Your Ref: OWPC6835
Our Ref: R/181/15/PL 15-07-2015
Please ask for:
Mrs A Gardner

Erection of 2 No. 3 bed dwellings, demolition of existing garage & shed & erection of new car port. Resubmission following R/305/14/PL. This application affects the character & appearance of the Station Road Conservation Area.
Land to the south of The Tiled Barn Station Road East Preston

Thank you for your internet representation made on 1st September 2015 which has been recorded as '**an objection**' with the comments as follows:

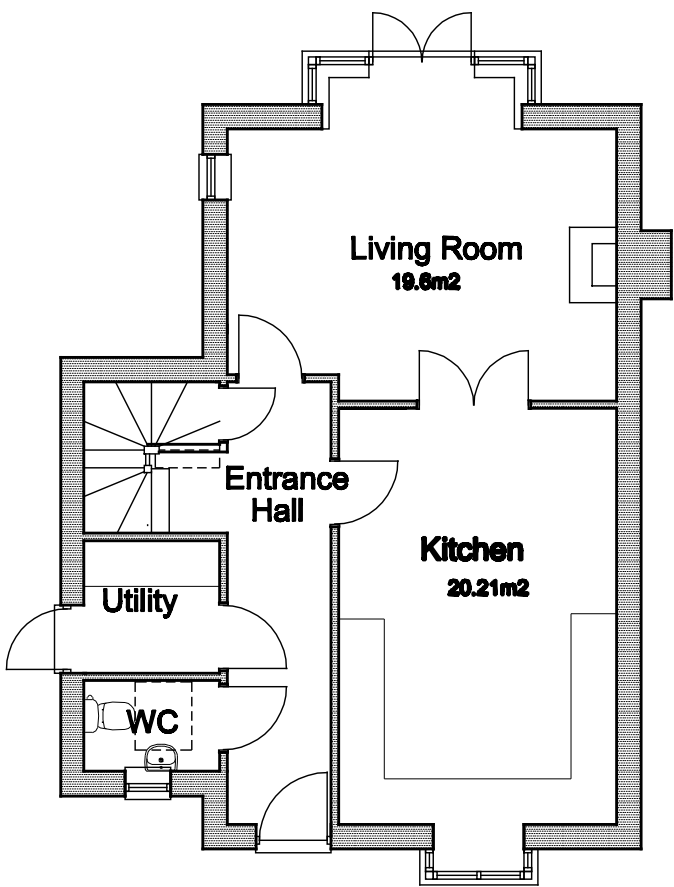
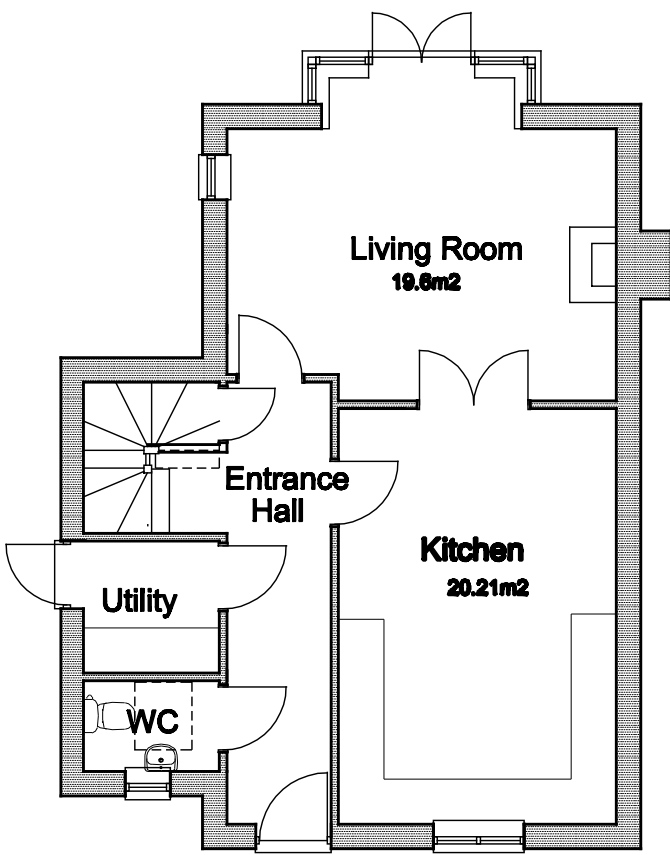
I wish to object to this application because the size and position of the two houses proposed would have a detrimental effect on the Rustington/East Preston Conservation Area, and in particular on the view across the road from East Preston Parish Church and from the green at the junction of Vicarage Lane and Station Road.

Because the site of the proposed houses is above the level of the road, this would make them particularly visible, which is contrary to section 2.3 "Standard of New Development in Conservation Areas" in the Supplementary Planning Guidance for such areas, which states that such development should not "impair views from the public vantage points or open space considered important to the special character and appearance of the area".

The photomontages of the proposed houses make it all too clear that these buildings would seriously damage the view from the church and from the public road. The existing buildings visible from this point (including the two converted barns to the north of the proposed houses) have character and a sense of history, which would be greatly diminished by having these two new houses dominating the bend in the road. At present the simple fence on the bend provides a neutral boundary to the Conservation Area and its special character - and thus does not distract from it. This is how the area should remain and the current application should therefore be refused.
